**From:** [REDACTED]  
**Behalf Of** simon taylor  
**Sent:** Wednesday, June 27, 2012 3:55 PM  
**To:** Able Marine Energy Park  
[REDACTED]  
**Subject:** Able Marine Energy Park- Representation On Behalf of Simon Taylor

**Able Marine Energy Park- Representation On Behalf of Simon Taylor**

My representations relate to the Compensation site only.

Figure 36.1 Existing drainage pattern at Cherry Cobb Sands

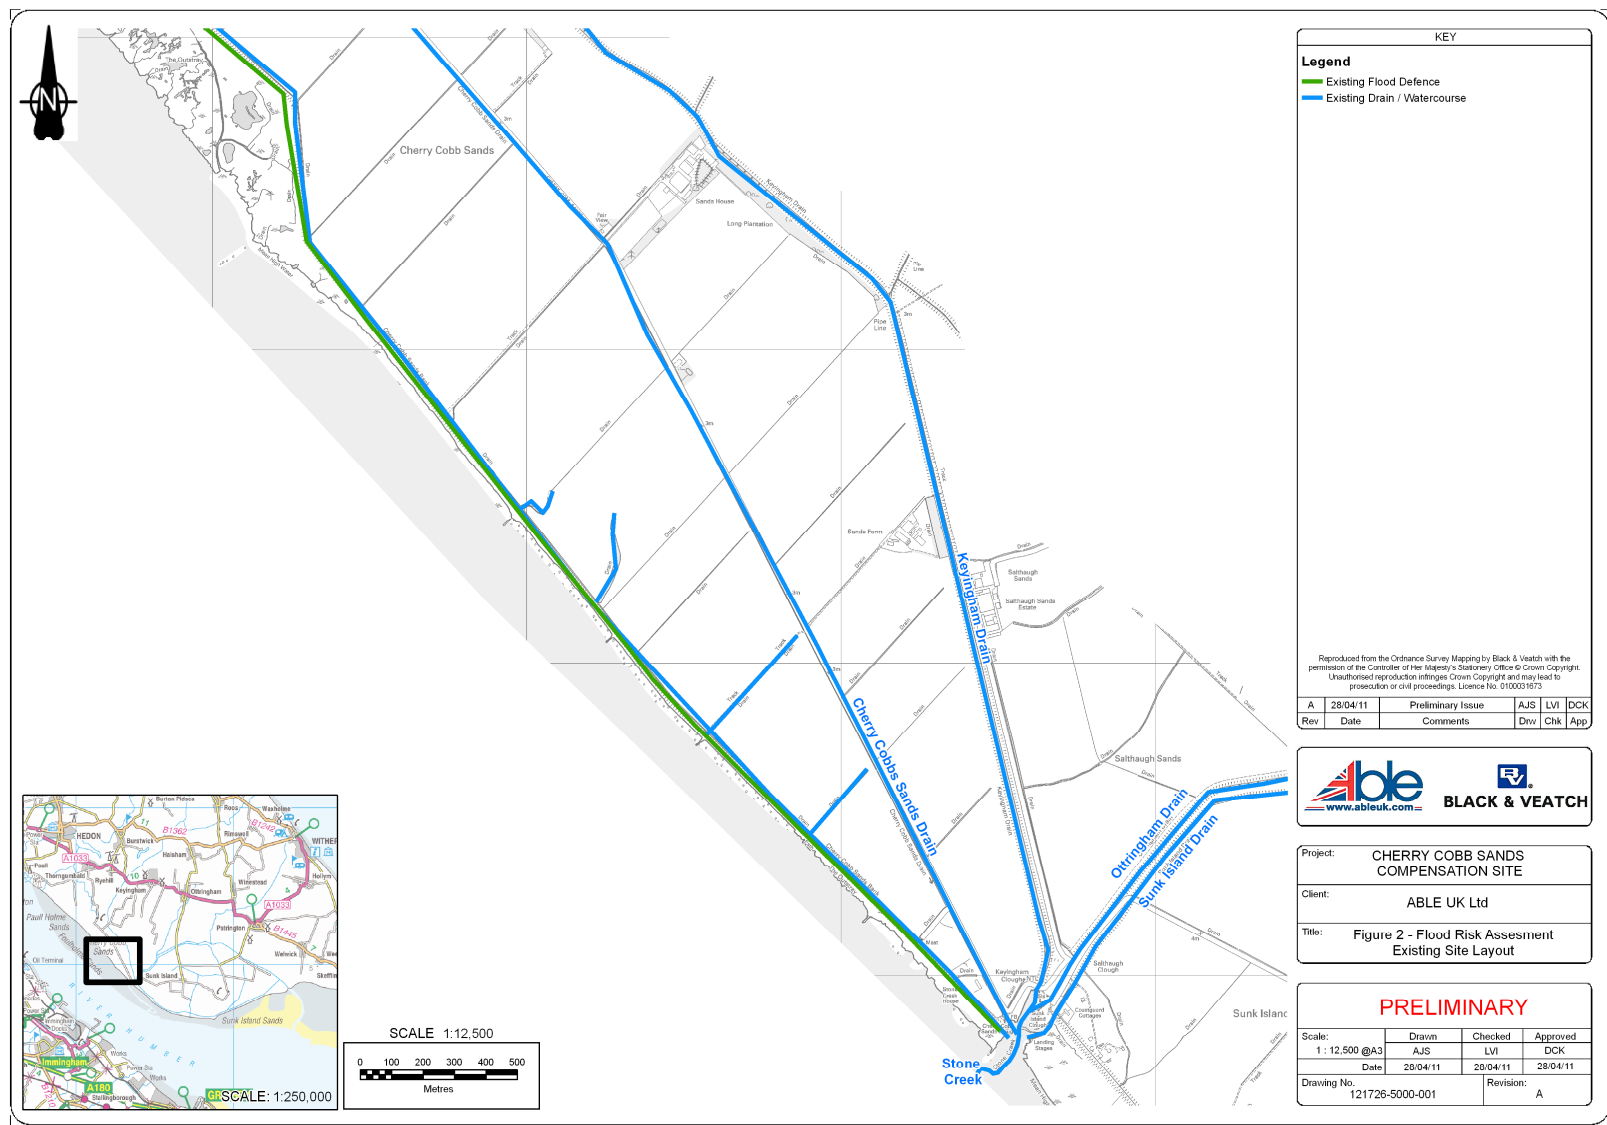
**Silting up of Stone Creek** – The developers' proposal say there will be additional silting of Stone Creek but do not discuss in detail or offer any remedial actions. Stone Creek is vital for the safe drainage of a very large area of Holderness any changes will increase flood risk. From the documents provided it is clear the developer has not grasped the importance of Stone Creek and the potential dire implications of their proposals.

The developer has only carried out a desk top study of Stone Creek and the immediate estuary and is therefore unaware of the full consequences their proposed development will have on the study area. The investigation work carried out so far is inadequate to support the application.
